**SOIL/SITE EVALUATION**  
**for ON-SITE WASTEWATER SYSTEM**

Owner: *MRH land* Holding Applicant:  
 Address: *168 Wild Woodway* Date Evaluated: *11-4-2020*  
 Proposed Facility: *SFR* Design Flow (.1949): *760 GPD* Property Size:  
 Location of Site: *Same* Property Recorded:  
 Water Supply:  Public  Individual  Well  Spring  Other  
 Evaluation Method:  Auger Boring  Pit  Cut  
 Type of Wastewater:  Sewage  Industrial Process  Mixed

Harnett County Department of Public Health Site Sketch

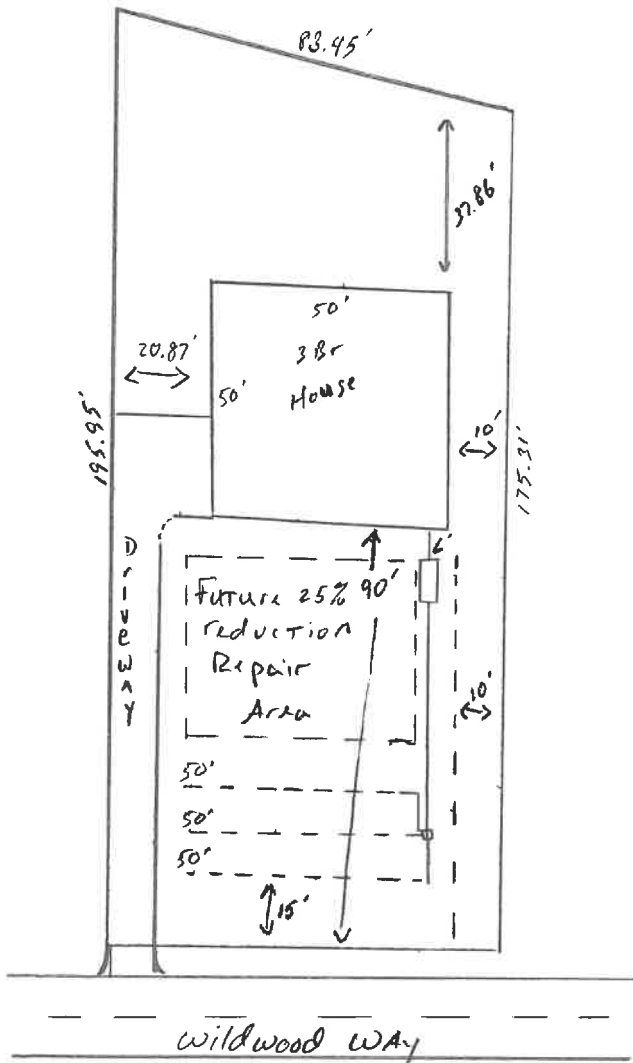
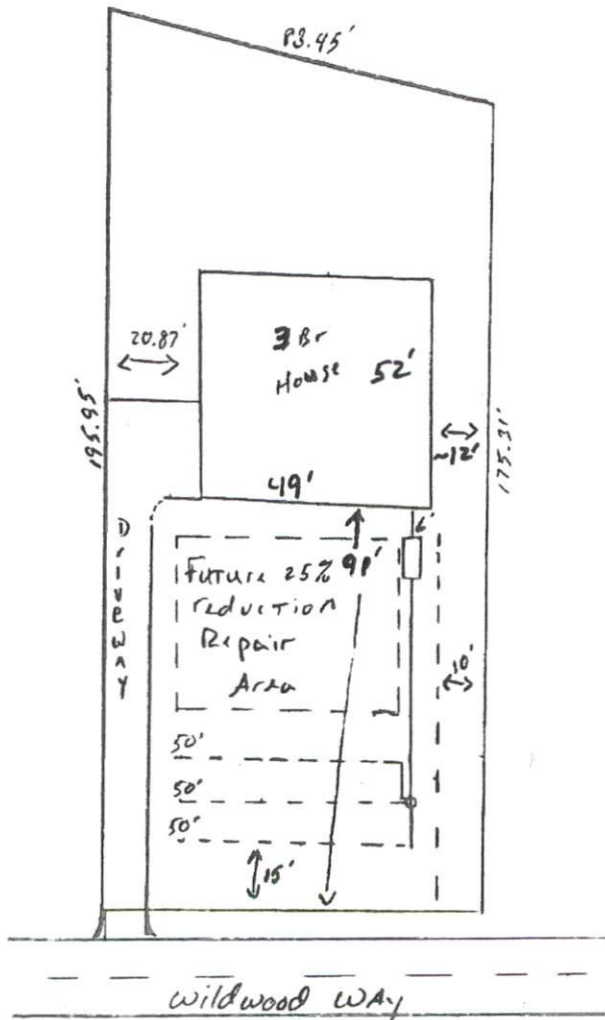
\* recommend move house  
 back by 40' to gain  
 access to suitable soils  
 for Drain Field + R.A.

Move hour box back as far as possible
